**OXFORDSHIRE COUNTY COUNCIL’S RESPONSE TO CONSULTATION
ON THE FOLLOWING DEVELOPMENT PROPOSAL**

Application no: 21/04171/F

Proposal: Re-development of part of existing car park to provide a drive-thru cafe within Use Class E; together with associated car parking, servicing and access; landscaping and all associated works

Response Date: 22nd June 2022

**Proposed Site Plan**

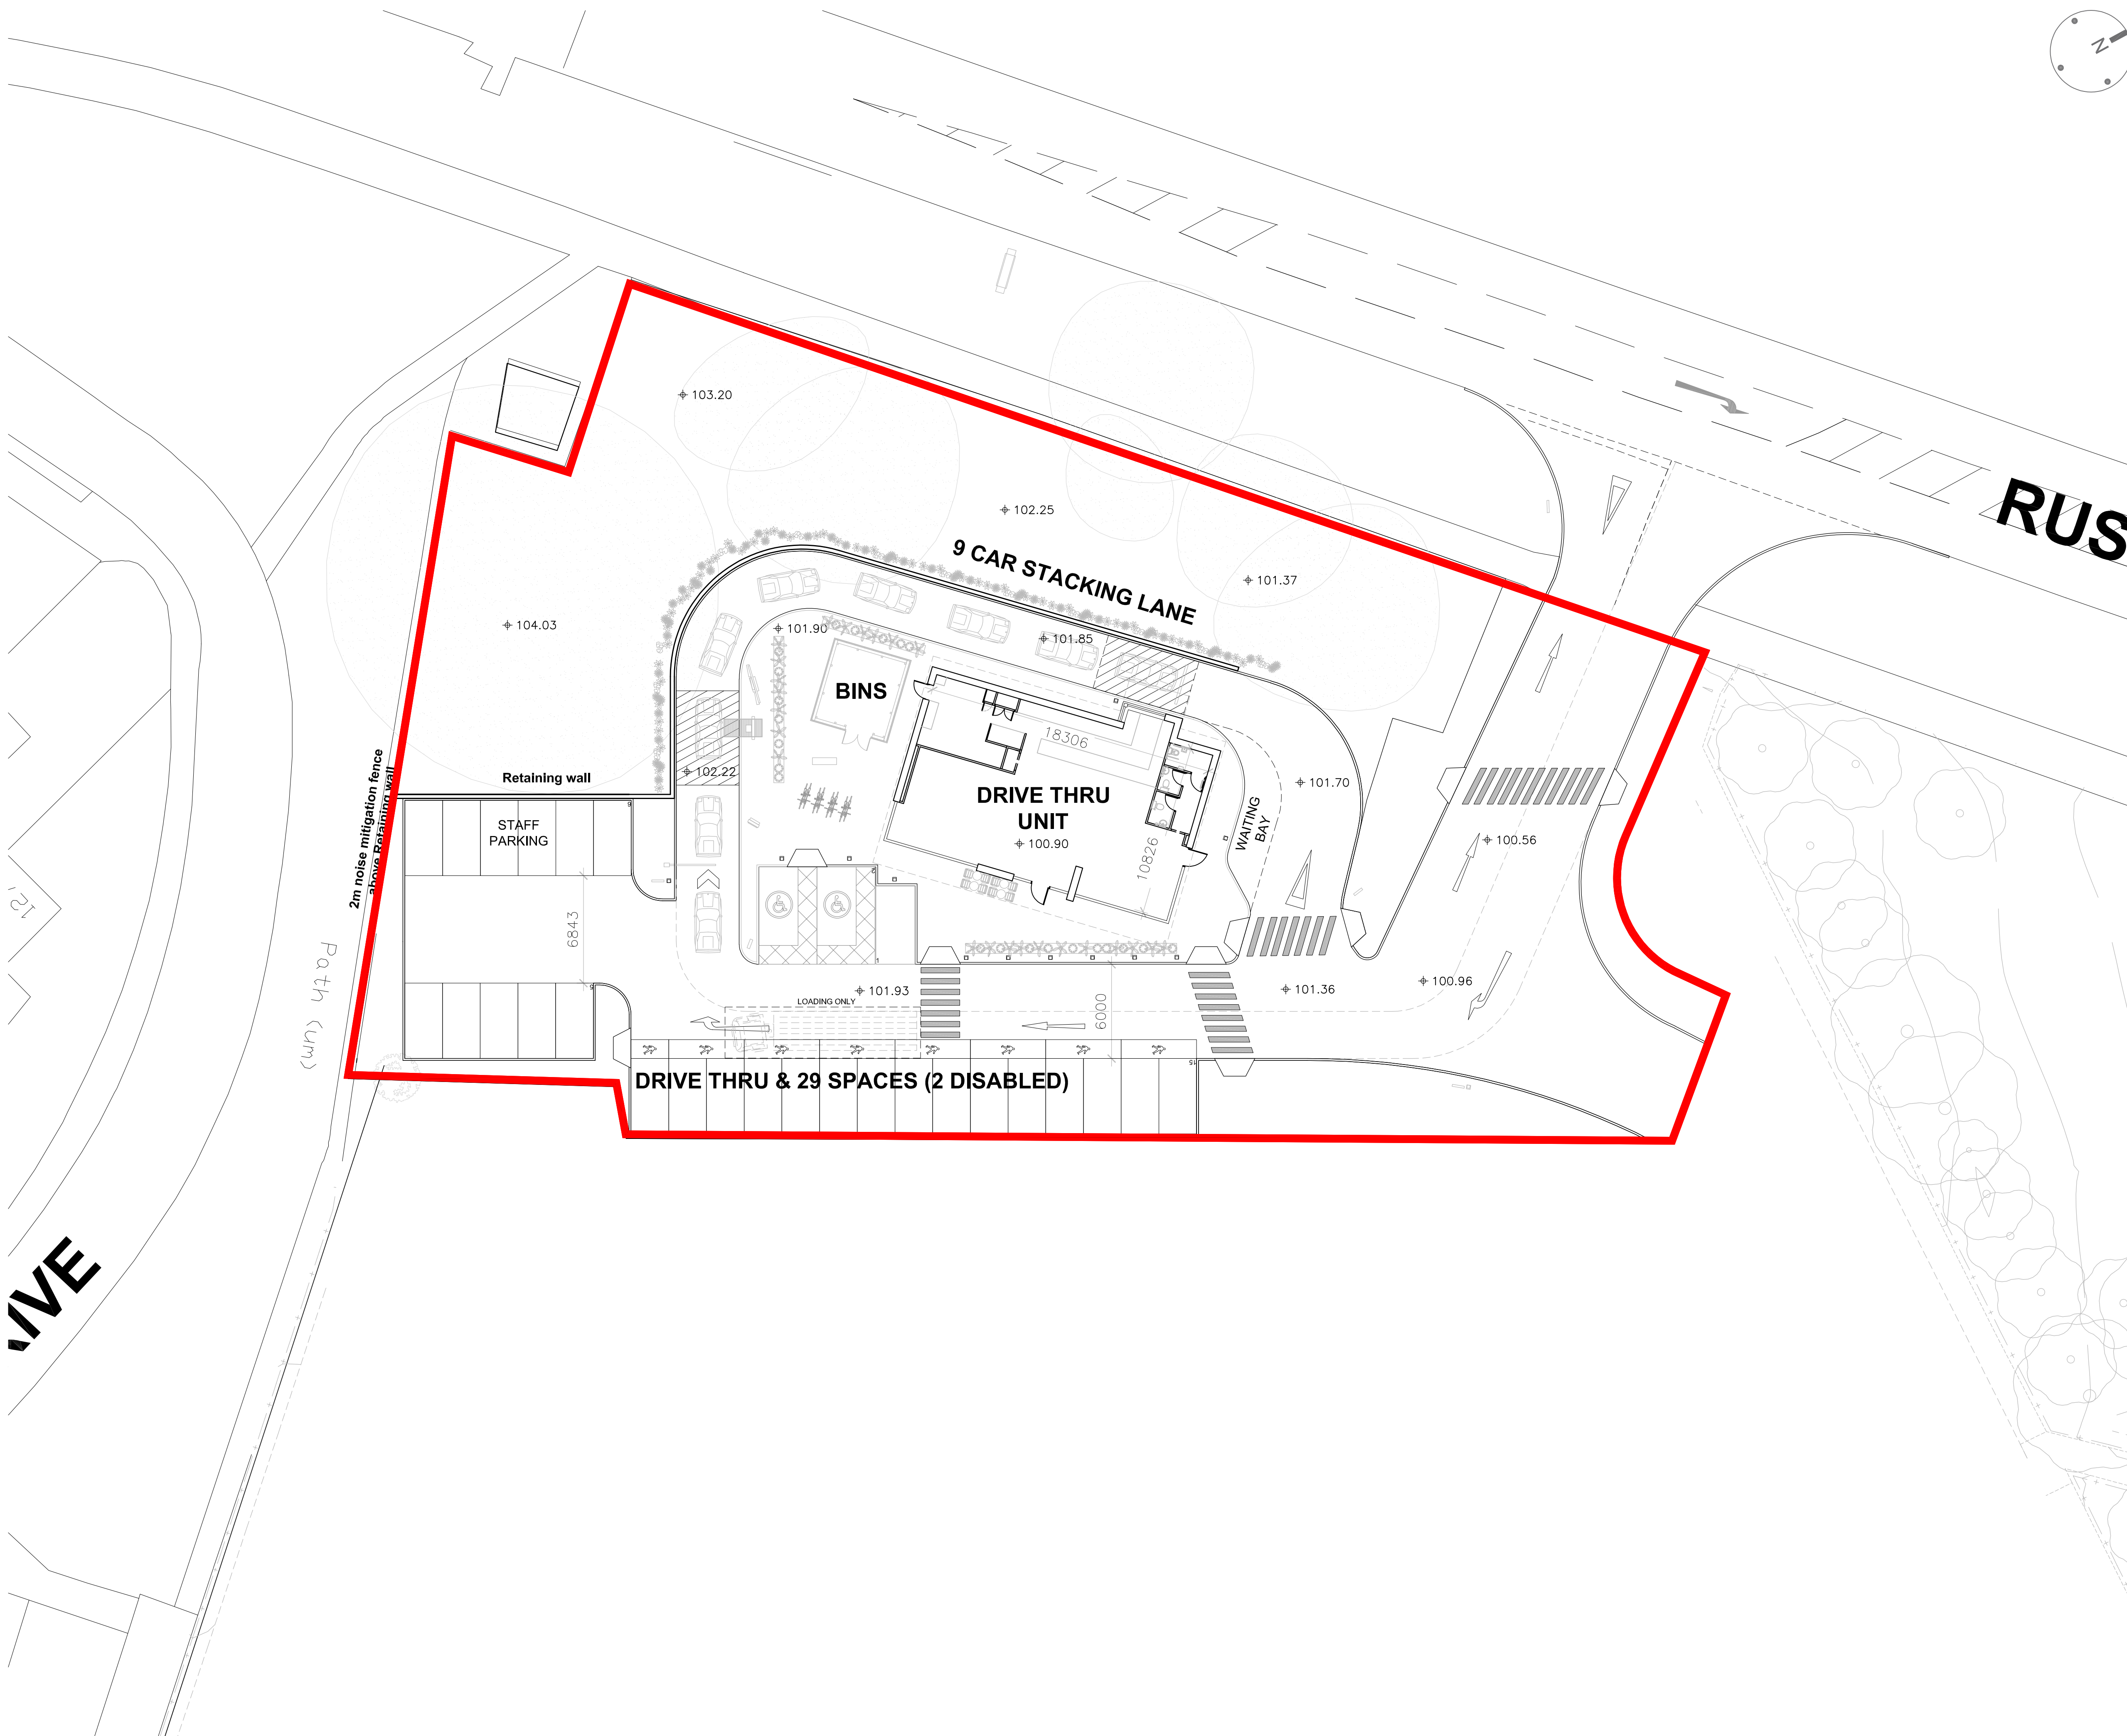
The layout has been amended to provide a designated area (by the access mouth) for use by delivery and refuse vehicles. This seems to be acceptable with respect to minimising conflict with circulating vehicles and with assumption that the turning head shall be utilised for such vehicles to turn around.

My concern then shifts to movement of goods and refuse bins between their respective storage locations. For deliveries, I expect these to be on rolling cages that need to be wheeled into the store - which appear to be located through the door adjacent to the bins. The safety associated with such movement with no dedicated path rather than utilising the circulatory drive leaves me concerned.

Also, it is not feasible to think that bins would be wheeled from their designated storage area to the loading every time refuse collection is made. The type and size of bins associated with such a development is the large and heavy type of bins that are not conveniently wheeled over such a distance. Besides, the route from the bin store

appears to have obstacles in the form of bicycle racks and hedge planting around.

The alternative arrangement requires bringing the refuse/ delivery vehicles closer to the southern end of the car park although this also presents a swept path challenge. It would also be unwise to consider wheeling the bins down the drive across the site. This remains the sticking point that requires a solution, without which HA support shall not be given on grounds of safety.
